## RESPONSE TO REVIEW COMMENTS

### **WALDEN PRESERVE 2 – AMENDED PRELIMINARY PLAN APPLICATION SP-18-005**

March 11, 2019

SHEET TITLE
FILING 7

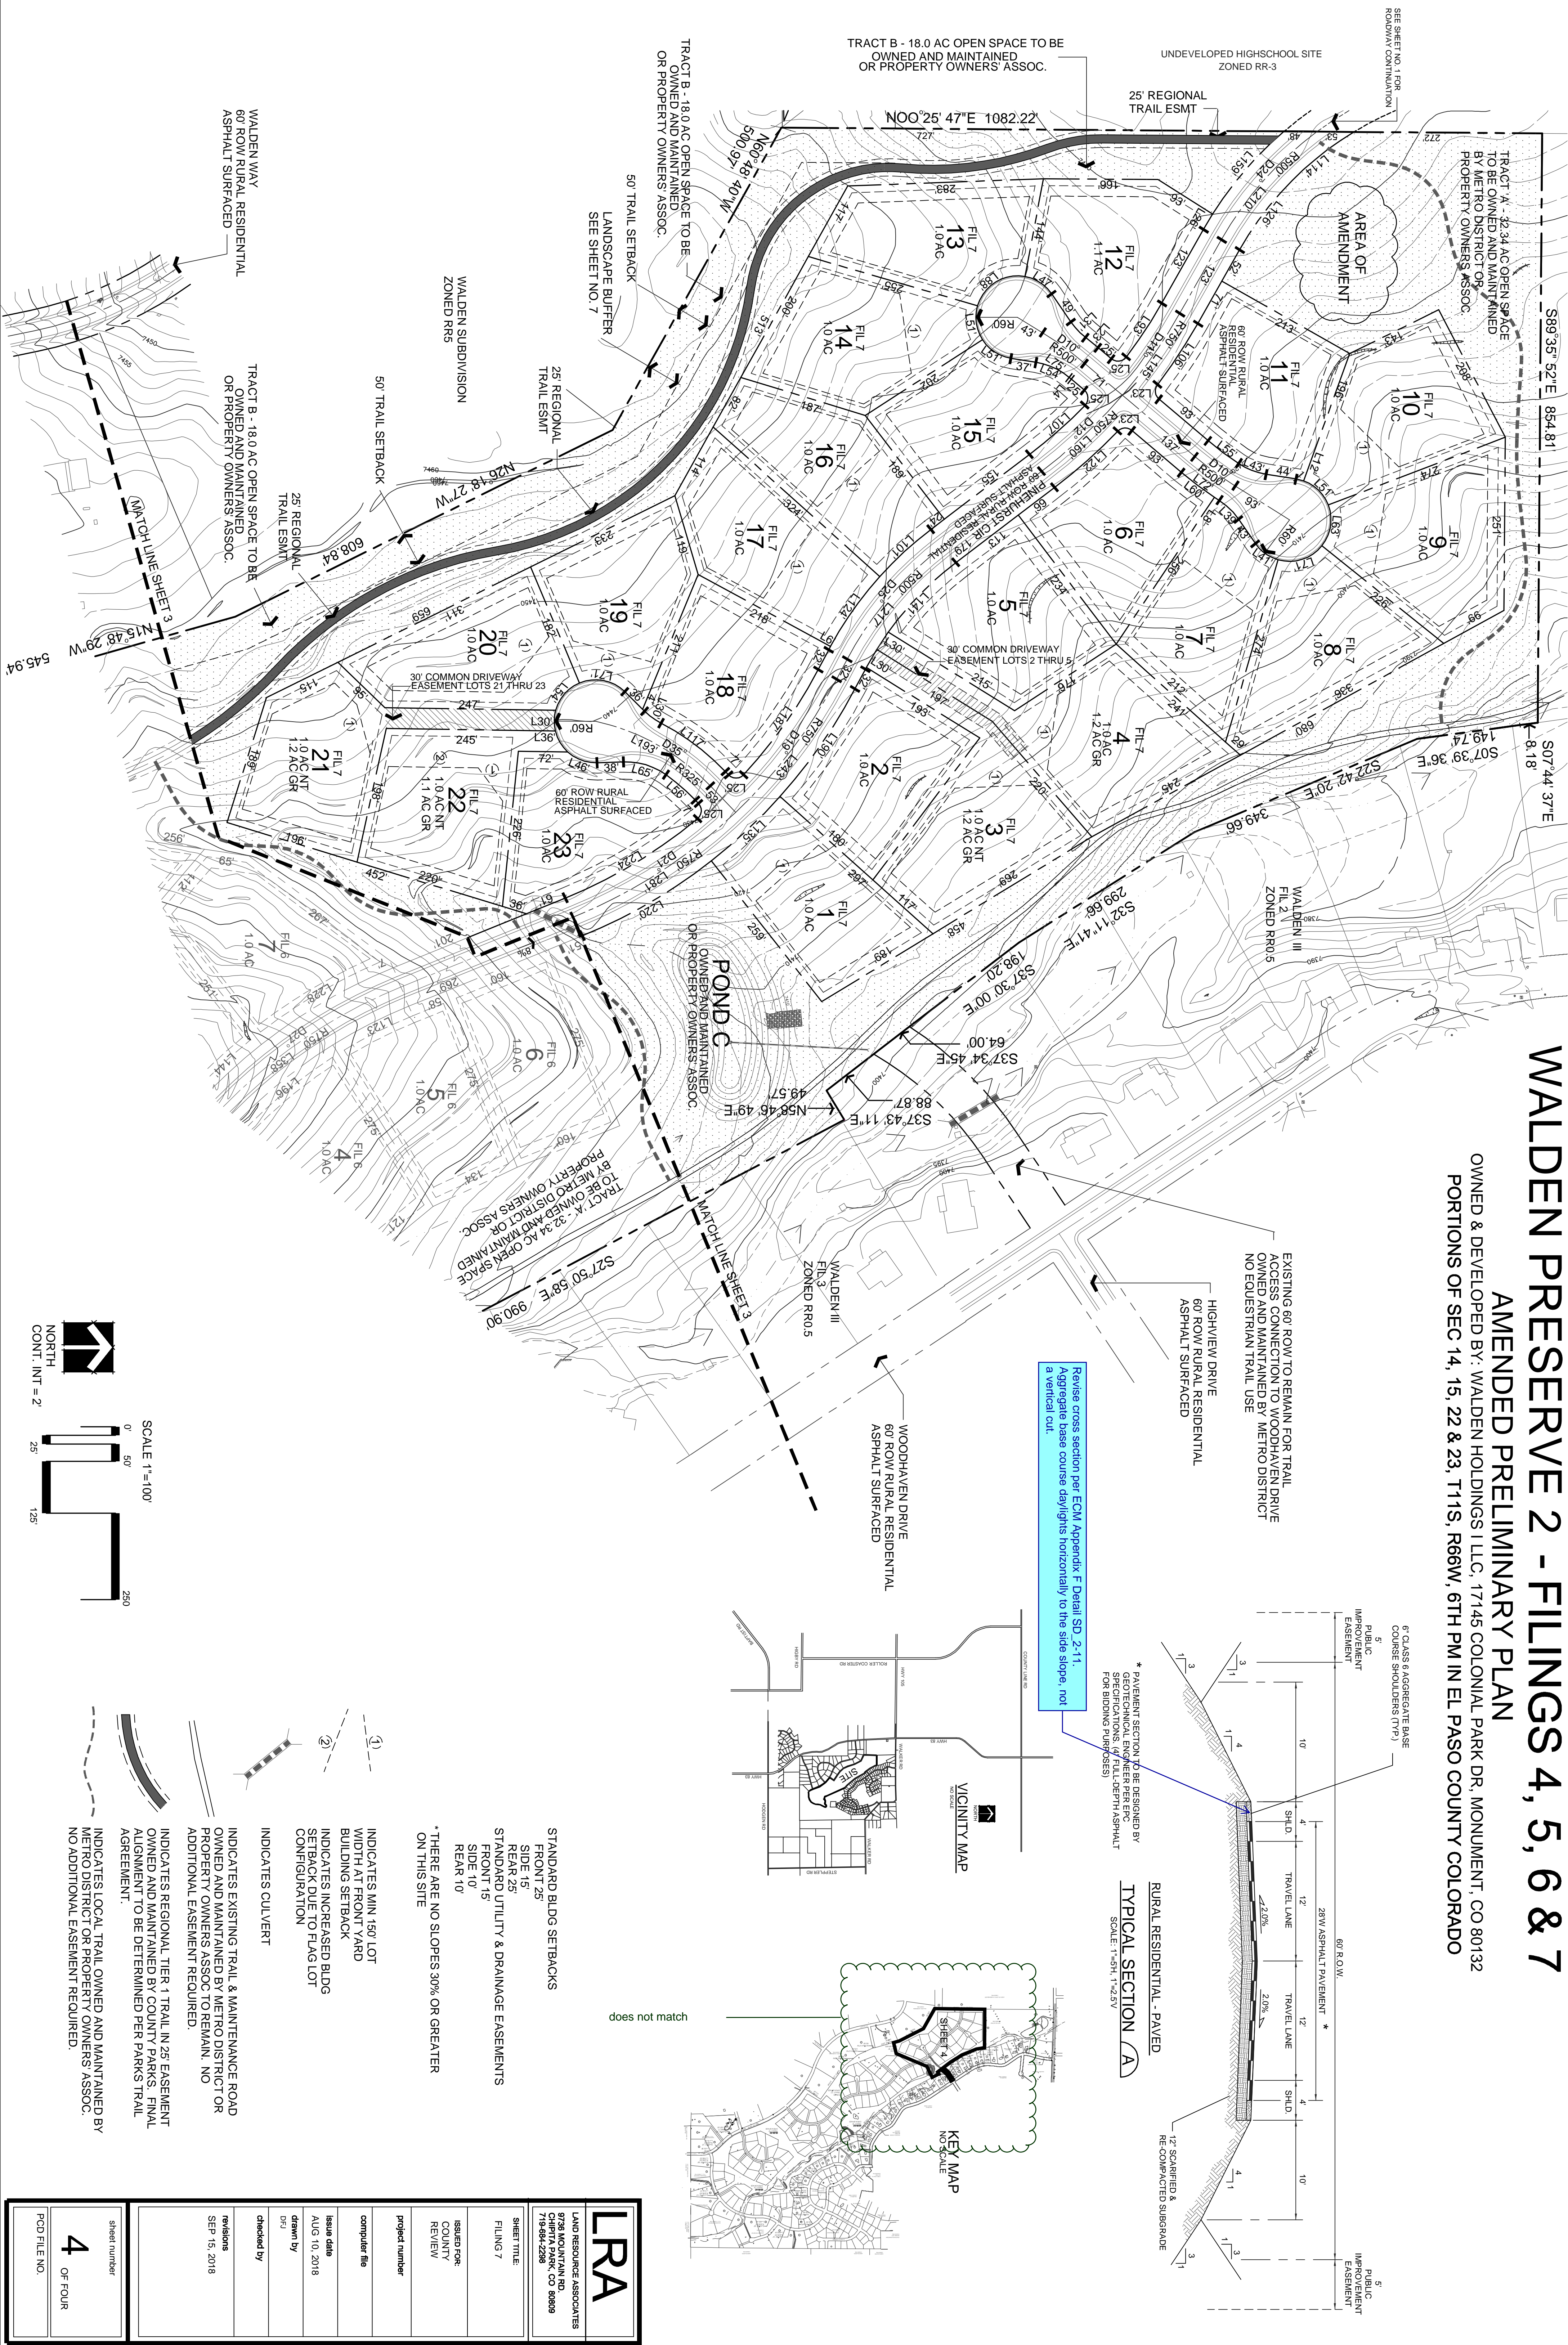
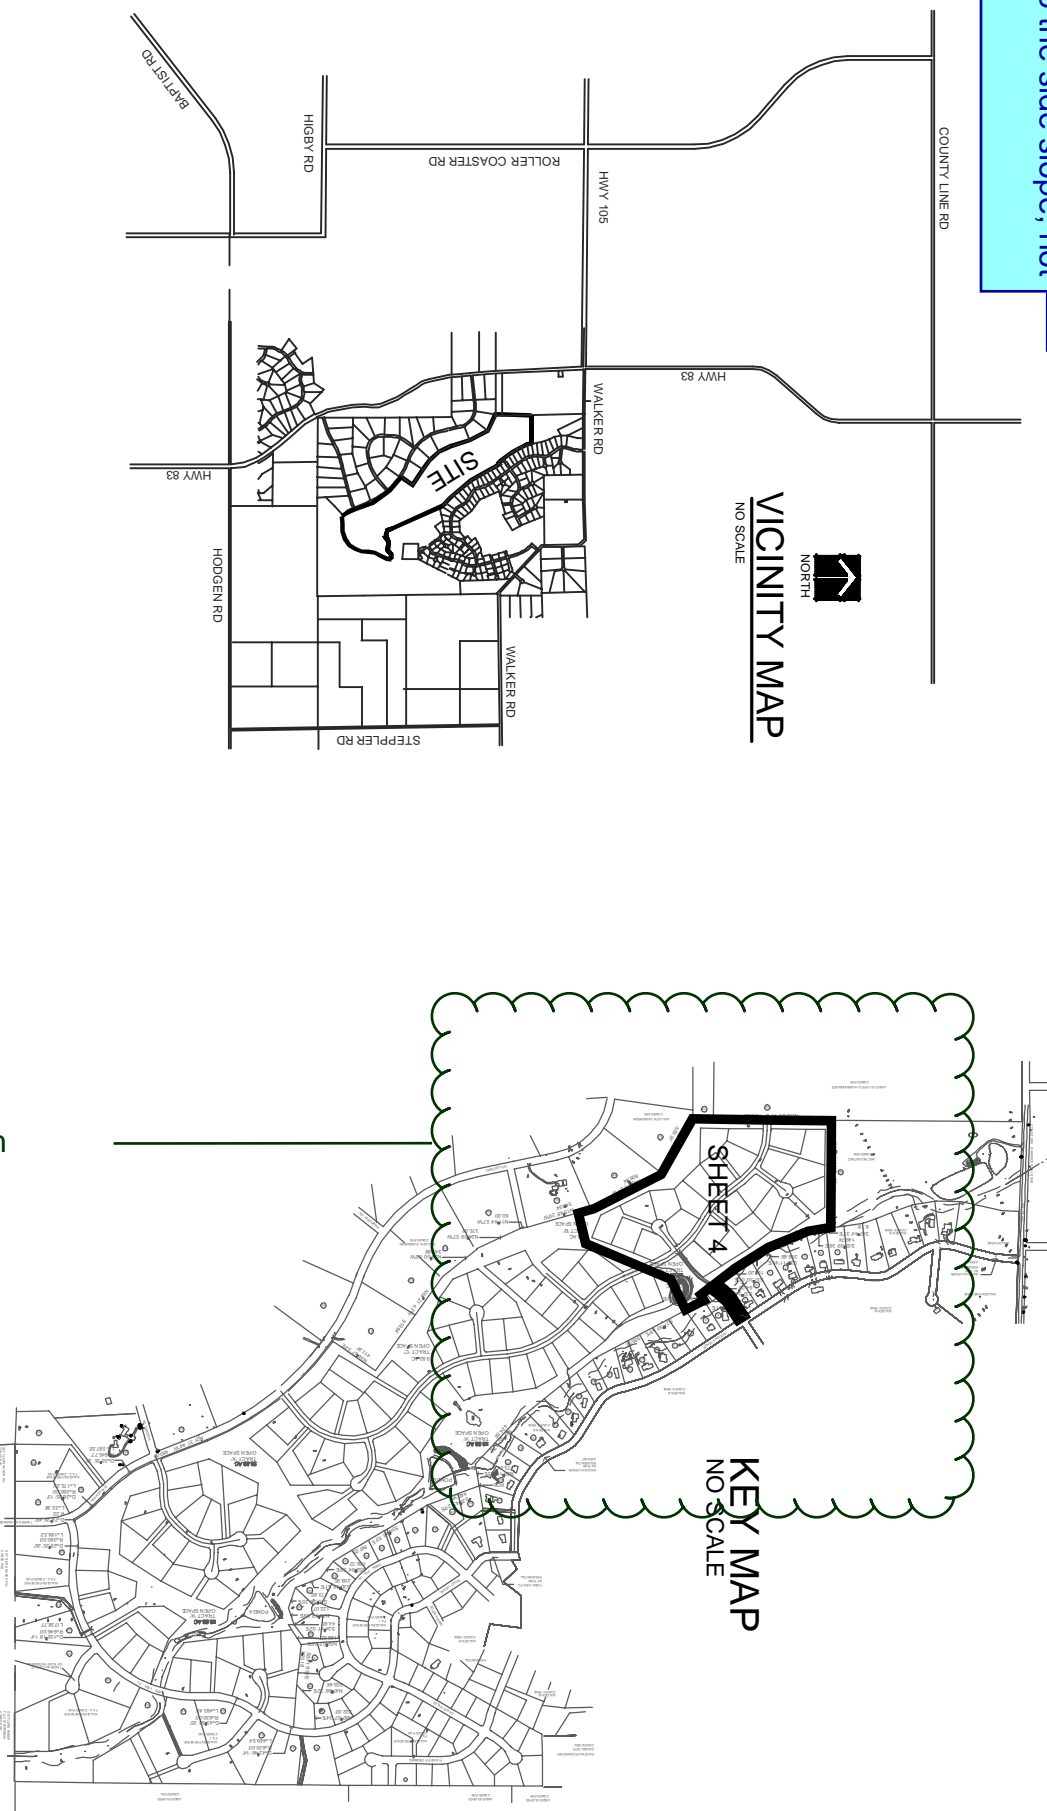
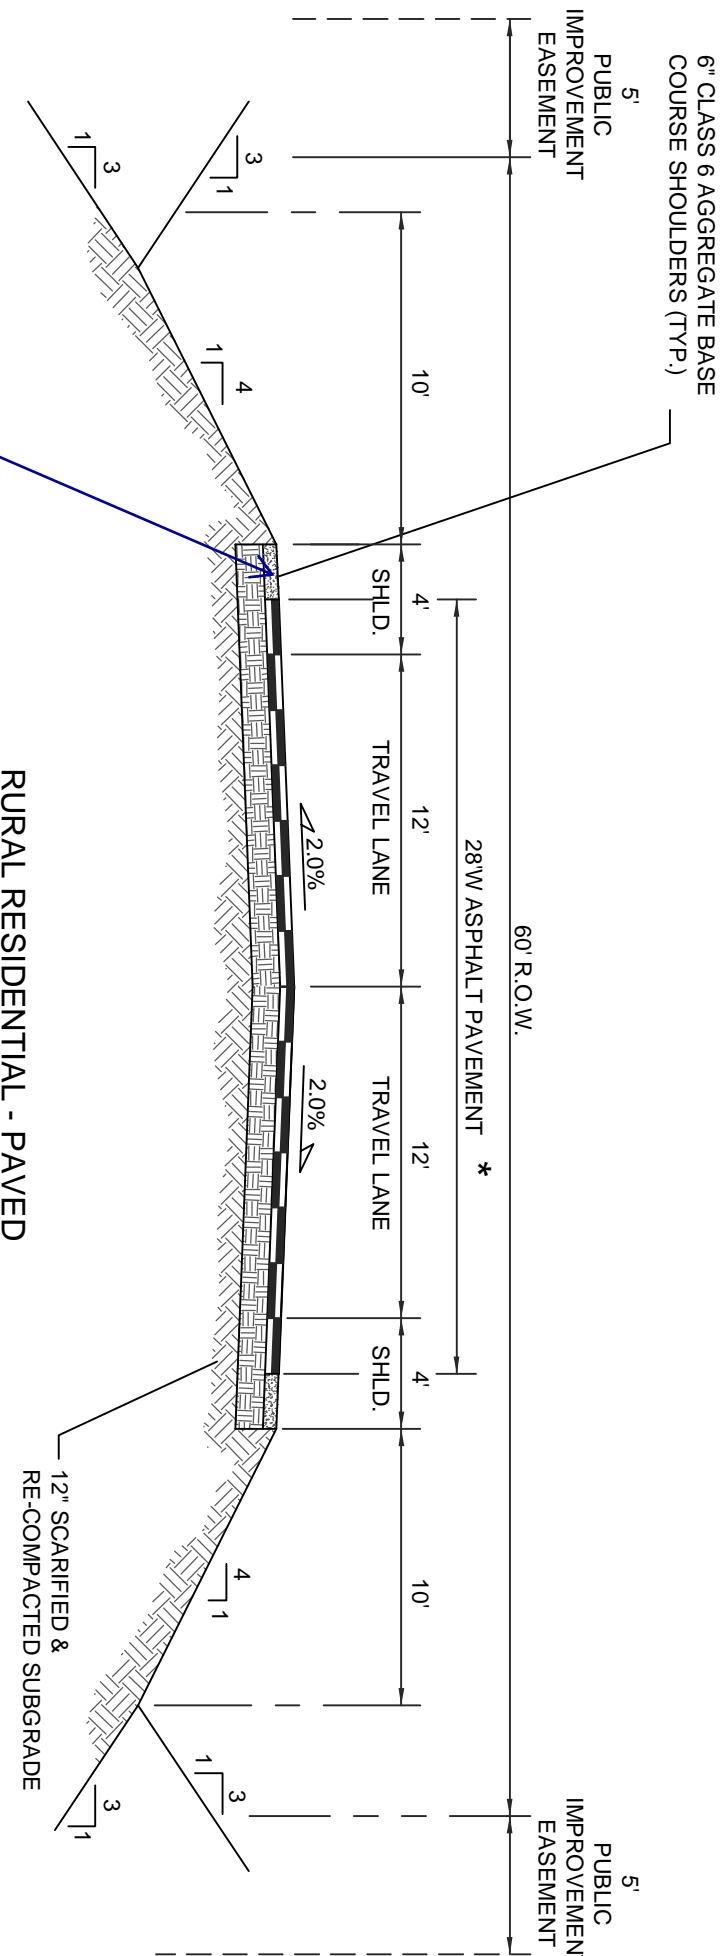
Sheet 4 – *Revise roadway cross section per ECM requirements* – The roadway cross section has been up-dated to reflect aggregate base course daylighting horizontally to the side slope.
